22 December 2011

Ms Holly Palmer
NSW Department of Planning and Infrastructure
23-33 Bridge Street
SYDNEY NSW 2000

**S.75W MODIFICATION TO MP10_0057 – RESPONSE TO ISSUES
132-138 KILLEATON ST, ST IVES**

PARKING LEVEL 1 -
ARCH 250

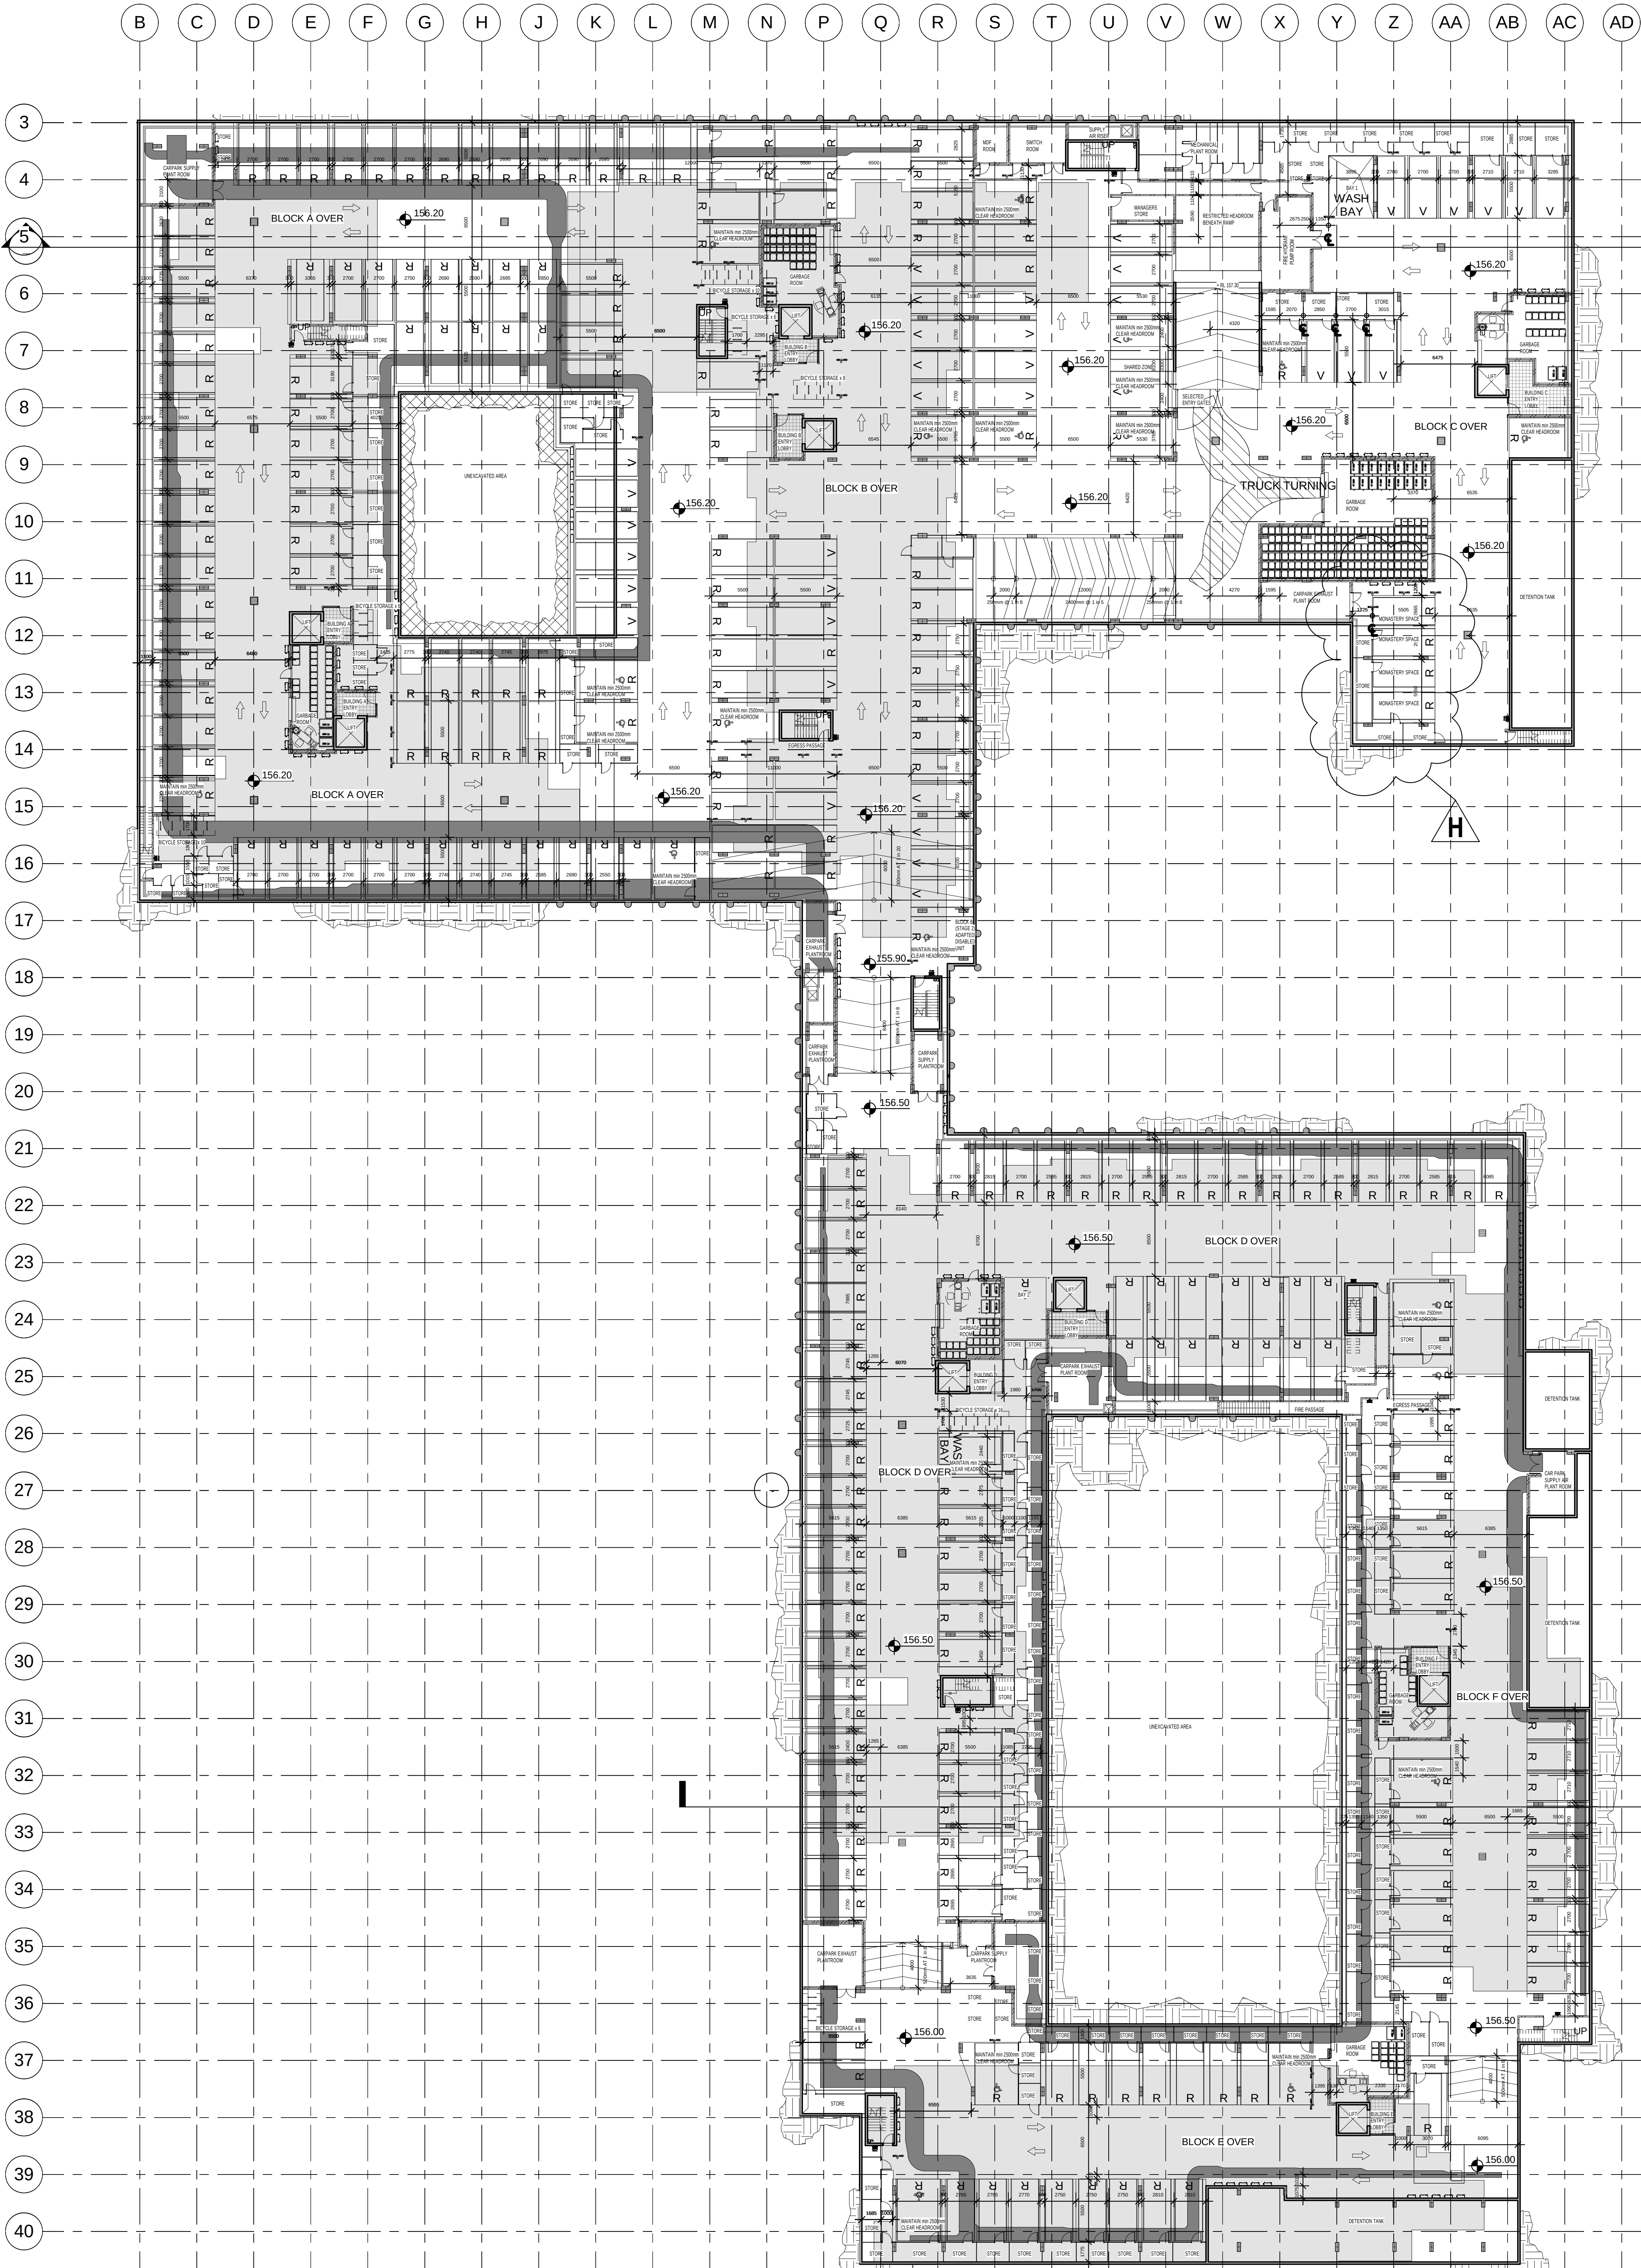
- *Details of the location of additional storage for the units.*

- *Carparking not satisfactorily addressed.*

Attached is a floorplan of the basement level of the development. Storage cages have been allocated to each of the 4 proposed units. The cages are shown clouded in conjunction with the car parking spaces – details in relation to proposed parking are addressed later in this letter.

Attached is a floorplan of the basement level of the development. The 4 required car parking spaces have been clouded on the plan and appropriately marked. The spaces are located in close proximity to the lift for Building C. This ensures the shortest travel path between the car parking spaces and the proposed units in the Monastery.
